PORTLAND MAINE

June 1, 2005

RE: Application for Minor Site Plan, 117-119 East Kidder Street
(CBL #425I028) (ID#2005-0093)

Thank you for your application for the 117-119 East Kidder Street Duplex. Upon review, the City has the following comments:

PROPOSED LOT 1
7174.76 SQ. FT.
0.16 ACRES

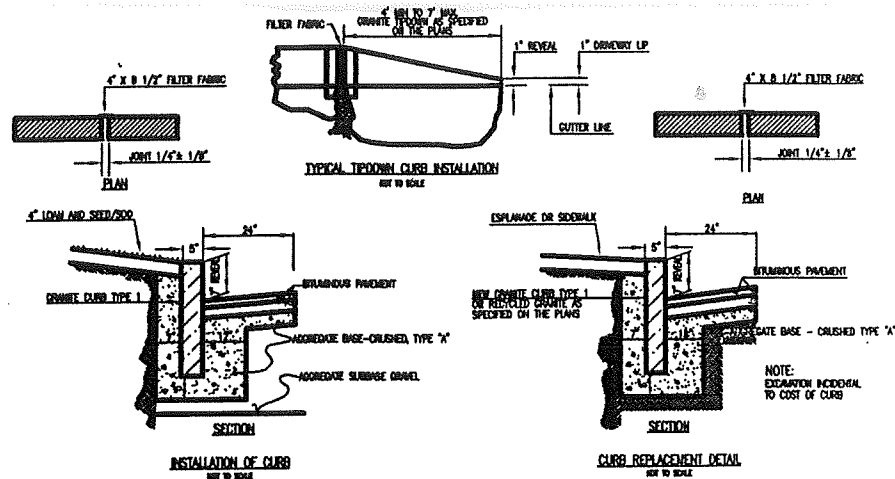
2. After further review, the proposal does not appear to be a subdivision.
3. Pertaining to the lot configuration, it appears that the 1-foot strip of land along East Kidder Street is not required for street frontage, as per section 14-403 of the land use code. Please remove this lot line.

5. Along with the parking requirements stated in Marge Schmuckal's letter, you will have to show the required parking for the existing 2 unit (4 spaces at 9'x19') on the site plan. Please shade in the parking/paved areas so that it is clear on the site plan.

6. Curbing and Sidewalk installation is a requirement for minor site plan. Please add to the plan, or if you wish to request a waiver of the standard, you must request a waiver and meet the criteria set forth in the enclosed standards.
